## PLANNING CONSULTATION RESPONSE

<b>Application No</b>	2025/0583
<b>Proposal</b>	Erection of detached two-storey dwelling with associated access and garage.
<b>Address</b>	Land adjacent St John the Evangelist Church, Carlton Road, Carlton, Barnsley.
<b>Date of Consultation Reply</b>	06/10/2025
<b>Consultee</b>	Katie Lawrence, Planning Ecologist

#### *Plans and Elevations (drawing no. 24-157 01)*

NORTH ELEVATION

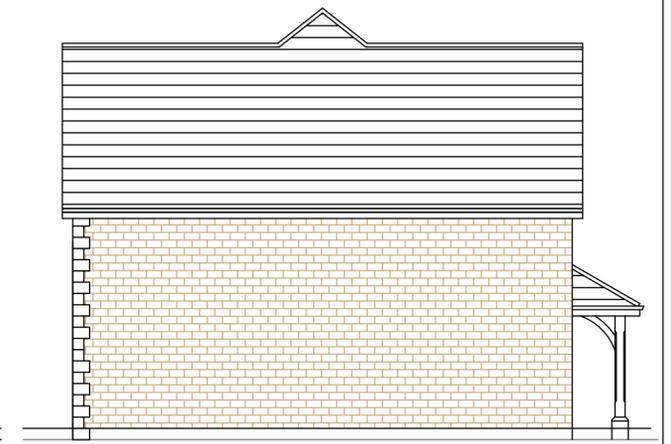
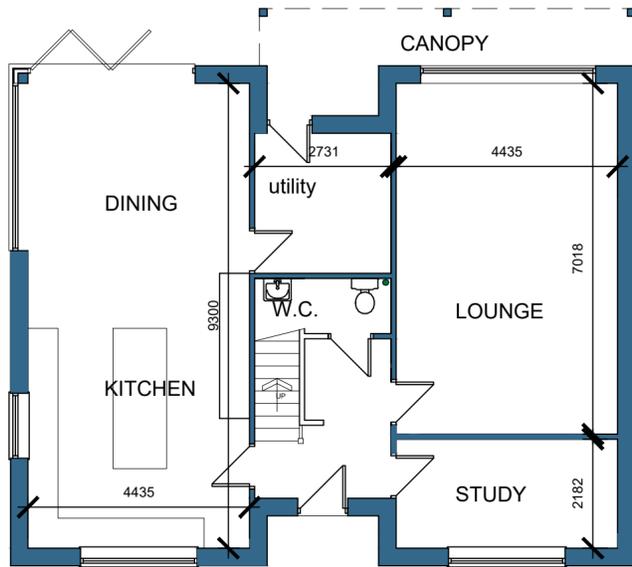
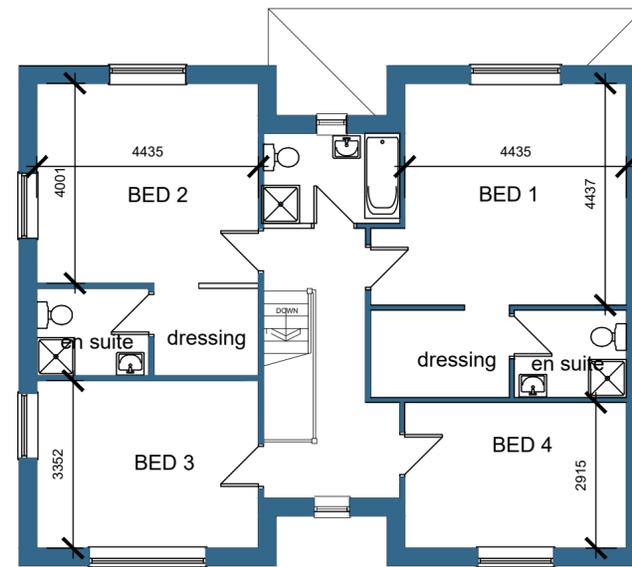
- The drawing titled plans and elevations includes proposed locations for a bat, swift and bee box on the proposed building and hedgehog access points within the boundary fencing, which is welcomed. The swift brick would ideally be located on the north or east elevation. If this can be amended these measures can be secured by a planning condition.
